WATER RESOURCE AND WASTEWATER REPORT

WOODMEN HILLS
METROPOLITAN DISTRICT

BENT GRASS RESIDENTIAL FILING NO. 2

JULY 2019

FINAL PLAT
BENT GRASS RESIDENTIAL FILING NO. 2
LOCATED IN THE NORTHWEST QUARTER AND SOUTHWEST QUARTER OF
SECTION 1 T13S R65W OF THE 6TH PRINCIPAL MERIDIAN
COUNTY OF EL PASO, STATE OF COLORADO

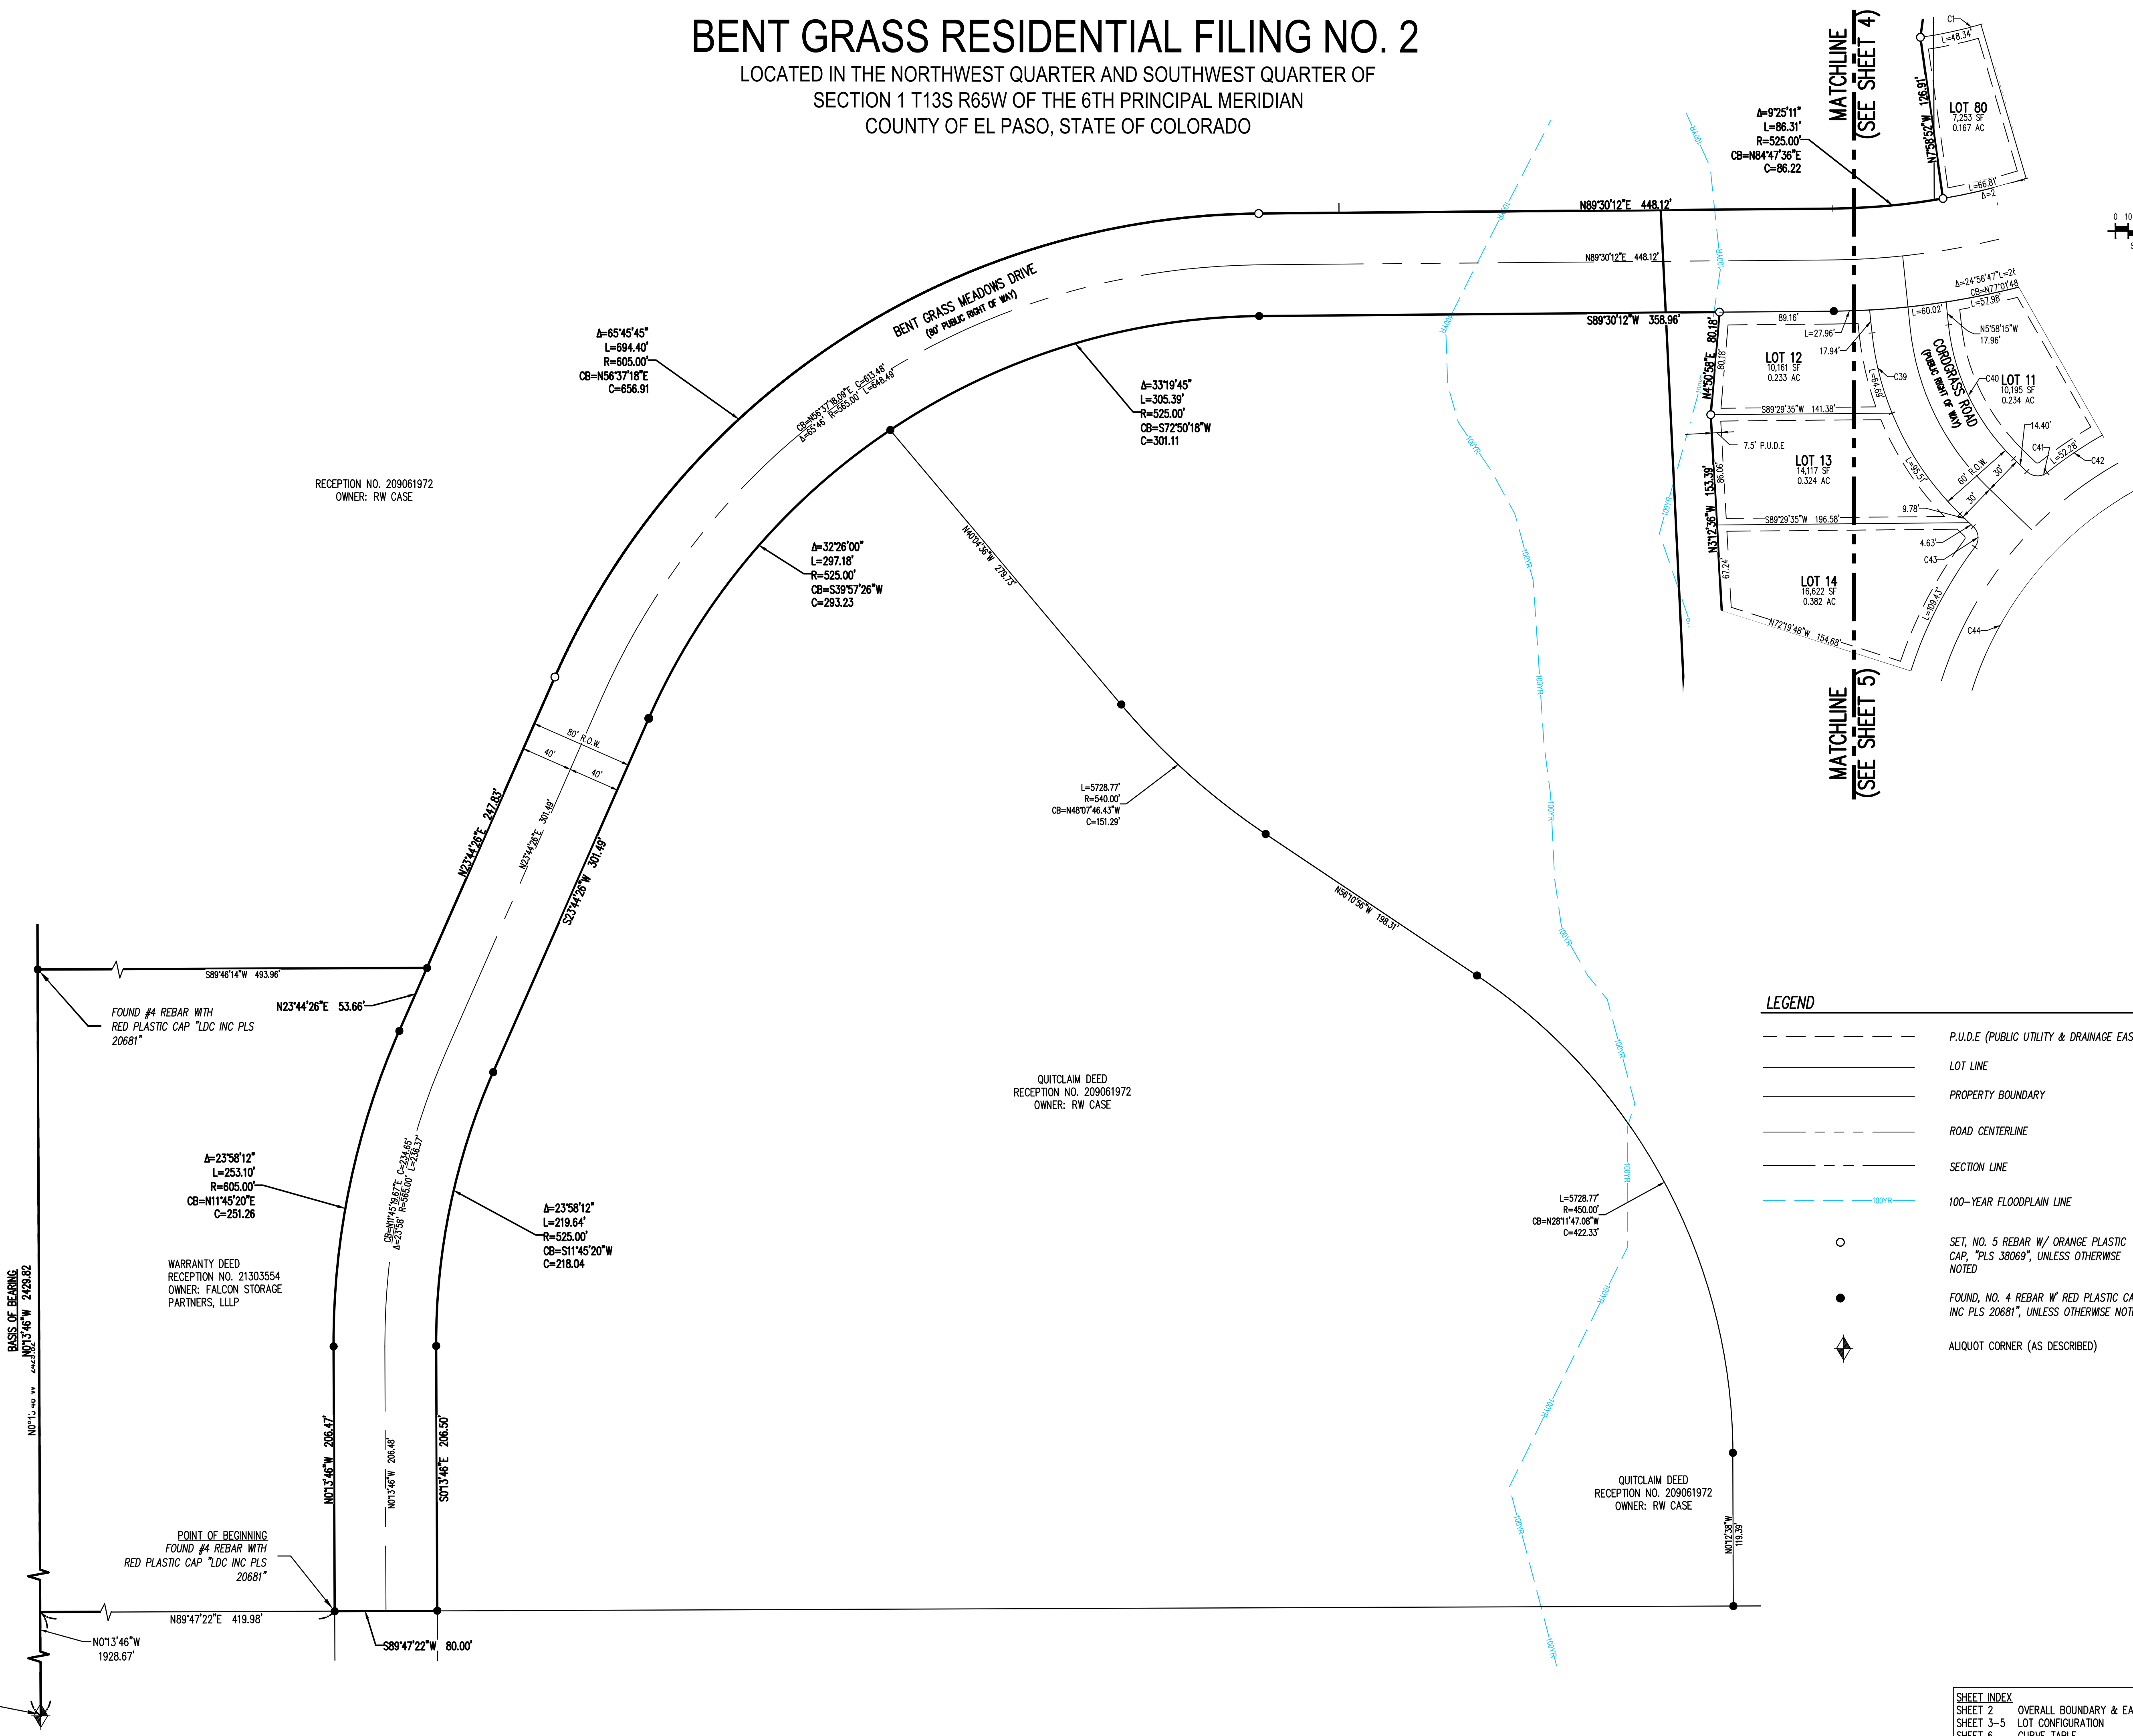
The water wastewater comt is for 121 lots. 177 as indicated in the application form, the LOI states 181 lots; The plat numbering is so confusing - its unknown how many lots are proposed
